# CITY OF ALBUQUERQUE

**Re: Paradise RV Park**  
**Volcano Rd NW- UPC 101106424915240520**  
**Request for Certificate of Occupancy- 30 Day Temp**  
**Transportation Development Final Inspection**  
Plan Approval Date 10-21-22 (K08D003)  
Certification dated 12-28-23

SITE DEVELOPMENT PLAN FOR BUILDING PERMIT
SCALE: 1"=50'-0"

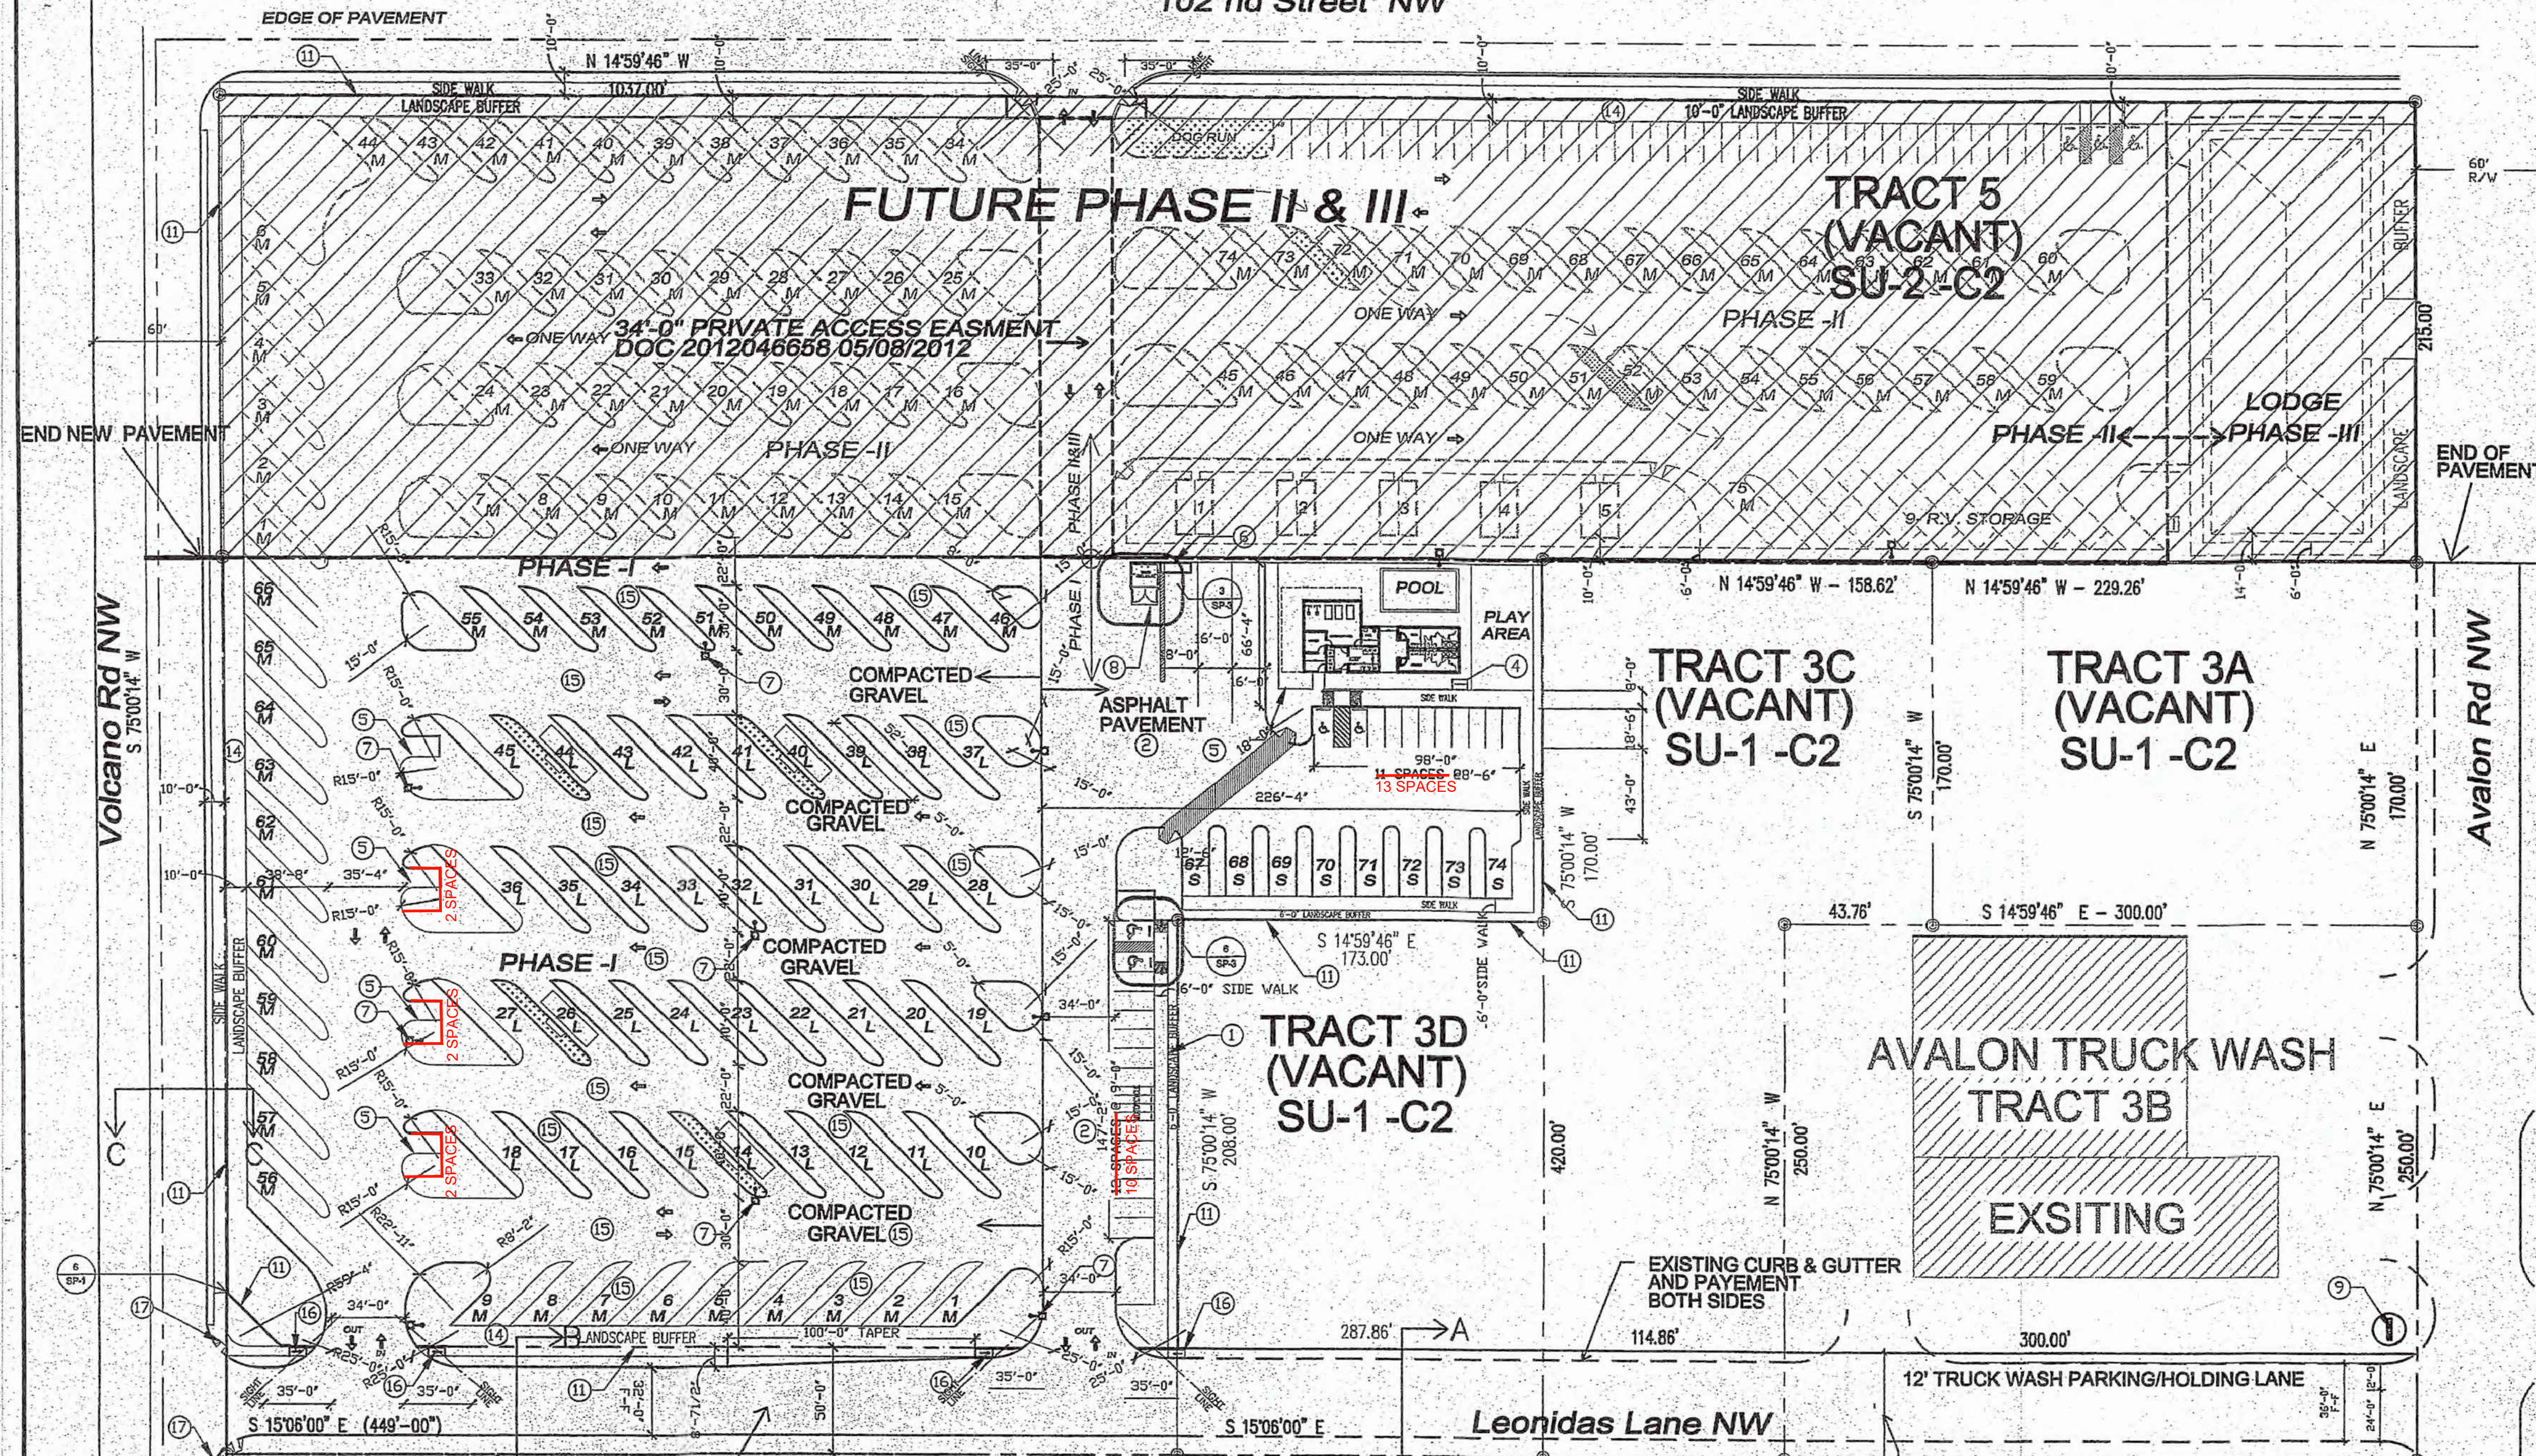
1. Replace the Accessible parking signs with signs that include the language: "VIOLATORS ARE SUBJECT TO A FINE AND/OR TOWING".
2. Add the pavement marking "NO PARKING" at the rear of the accessible Aisle.
3. Have a sign for each motorcycle parking space.
4. Two of the ramps were not flush with the adjoining parking surface.
5. The ramp west of the accessible parking and at the corner (in area of 6/SP-3 Detail on Sheet SP-1 and discussed on-site) had a slope of approximately 12.5%, whereas, the max allowable slope is 8.3%. Replace the ramp with a ramp with an acceptable slope.
